PLANNING CONSULTATION RESPONSE

Application No	2025/1075
Proposal	Change of use from a 6-person HMO (Class C4) to an 9-person HMO (Sui Generis) (Amended Plans and Description.
Address	61 Longman Road, Barnsley, S70 2LD
Date of Consultation Reply	30.06.26
Consultee	Stacey Fieldsend-Case Management Officer

PROPOSED FLOOR PLANS
SCALE 1:100 @ A3
REV D

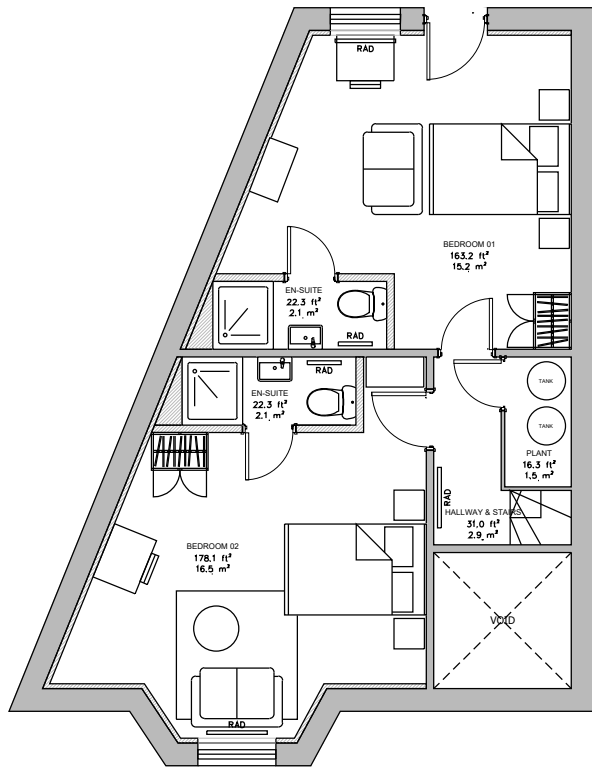
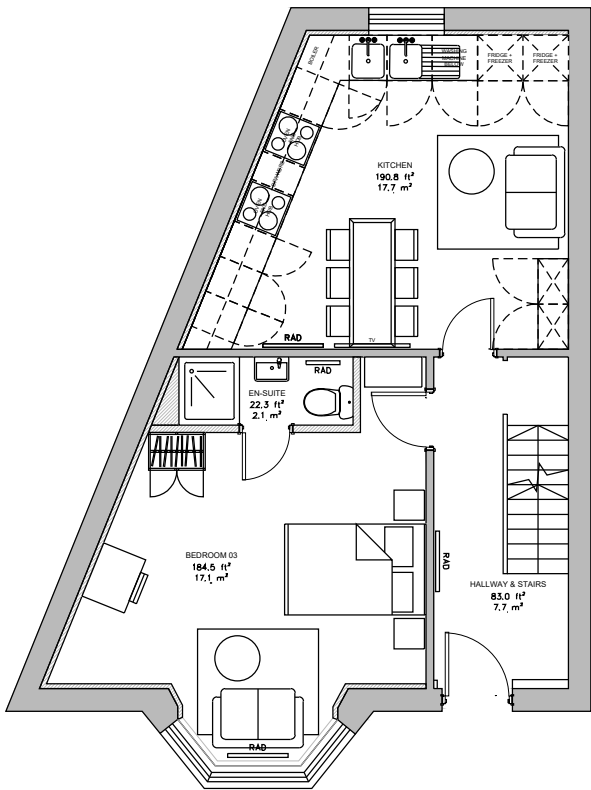
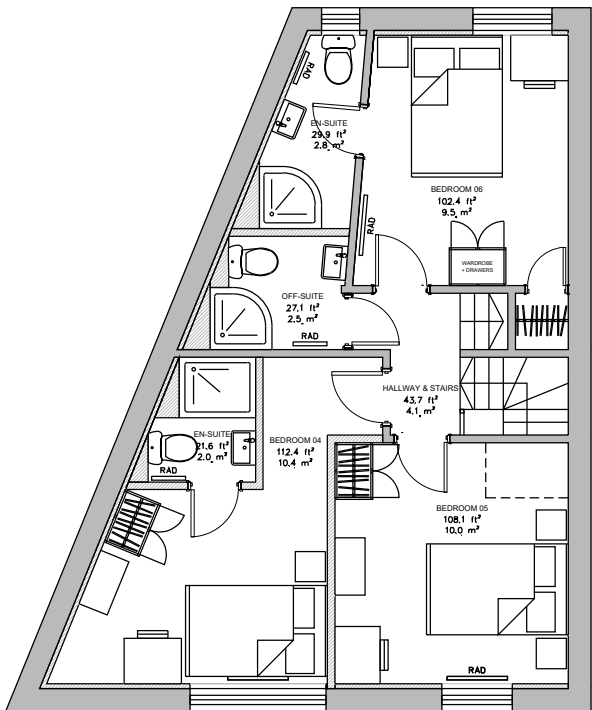
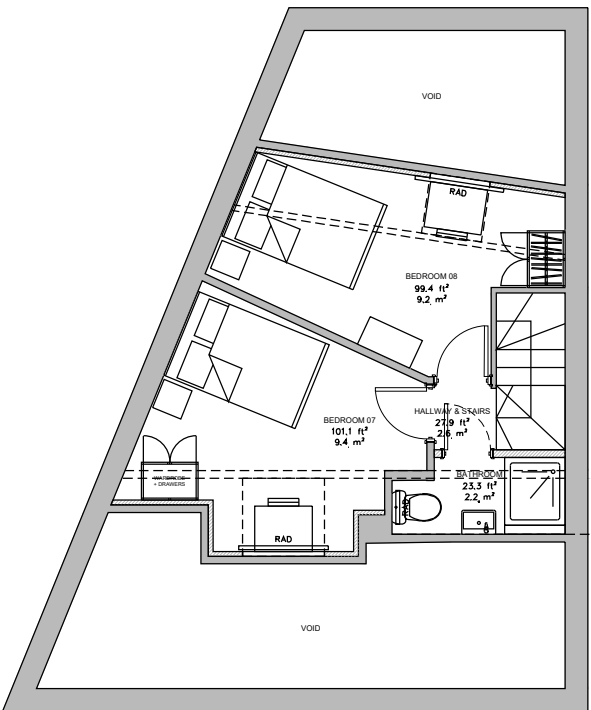
The amended layout indicates that only the occupants of Room 1 would have direct access to the rear garden. As such, the rear garden would not provide a practical or accessible location for communal bin storage for all occupants. Without suitable alternative provision, there is potential for waste and recycling bins to be stored inappropriately, which may impact the appearance of the street scene and residential amenity.

Prior to occupation of the property as a 9-person HMO, details of adequate waste and recycling storage facilities shall be submitted to and approved in writing by the Local Planning Authority. The approved facilities shall be provided prior to occupation and retained for the lifetime of the development.
